Floor Plans V_1 redlines.pdf Markup Summary 10-17-2019

FINAL PLAN 123K

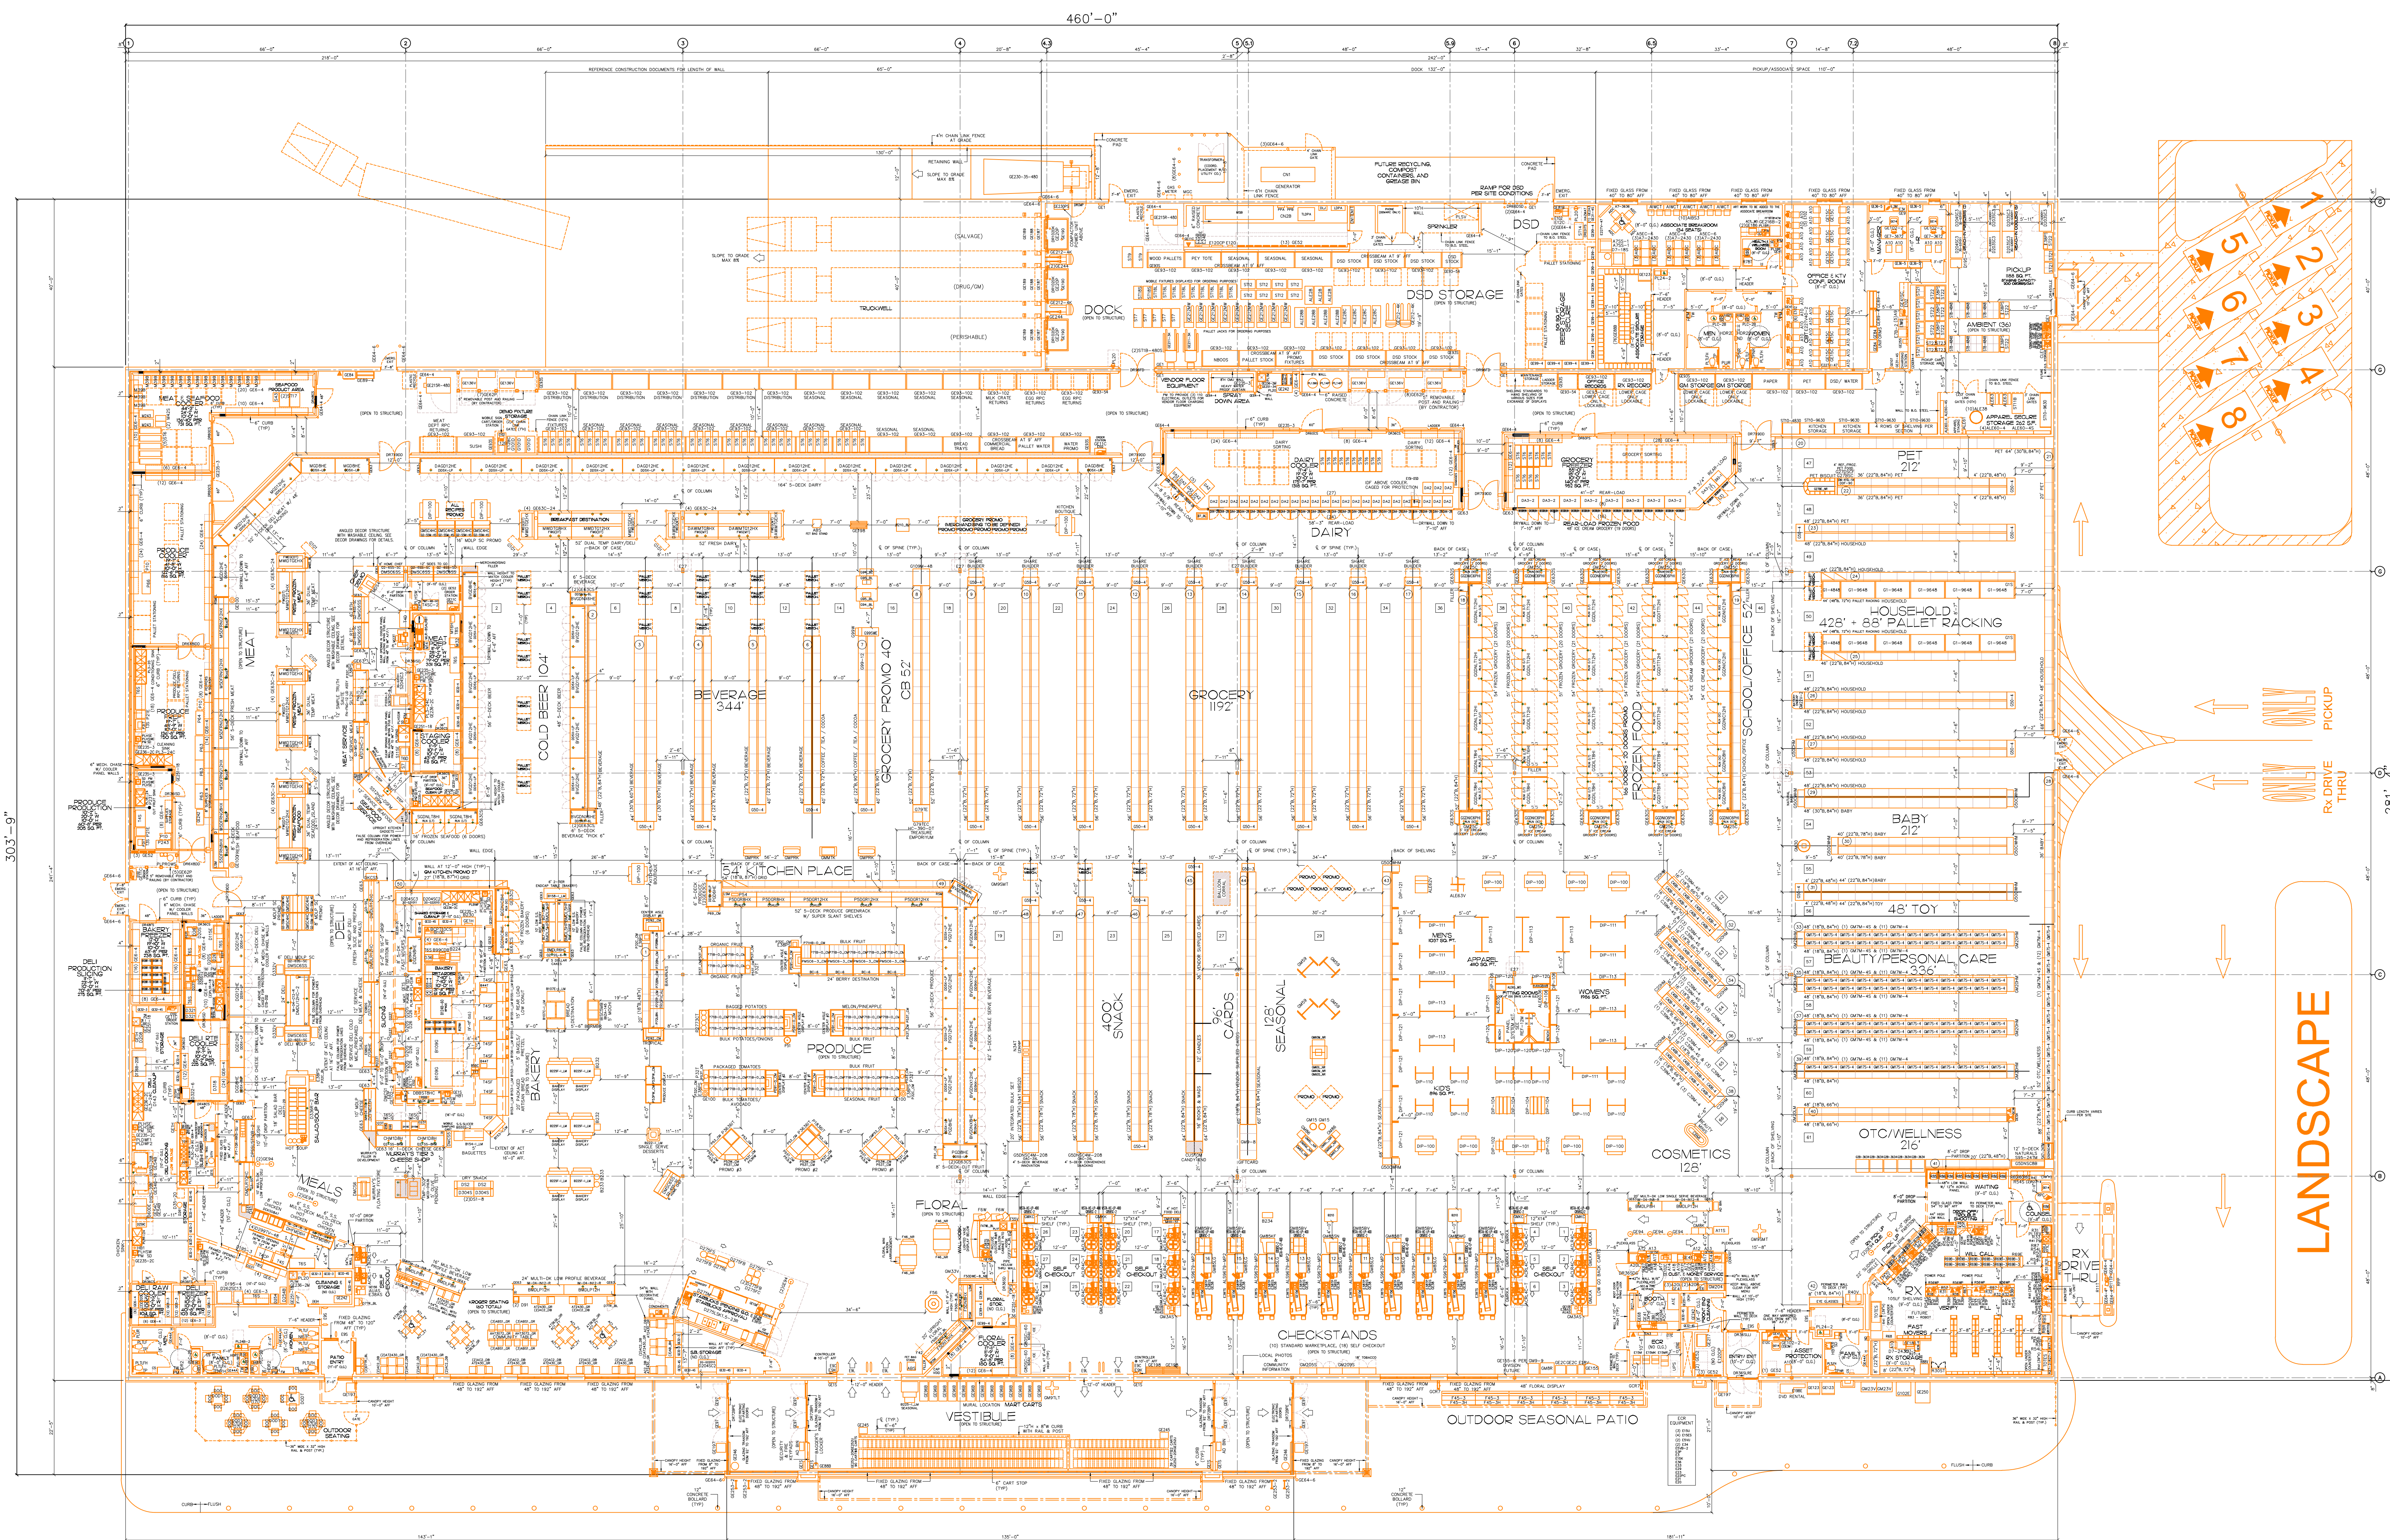
Provide final floor plans - these appear to draft

these plans do not match the SDP sheet. The gas and drive thru are on the east side on the SDP- the only thing on the SDP sheets is the loading docs. See Elevations, and SDP
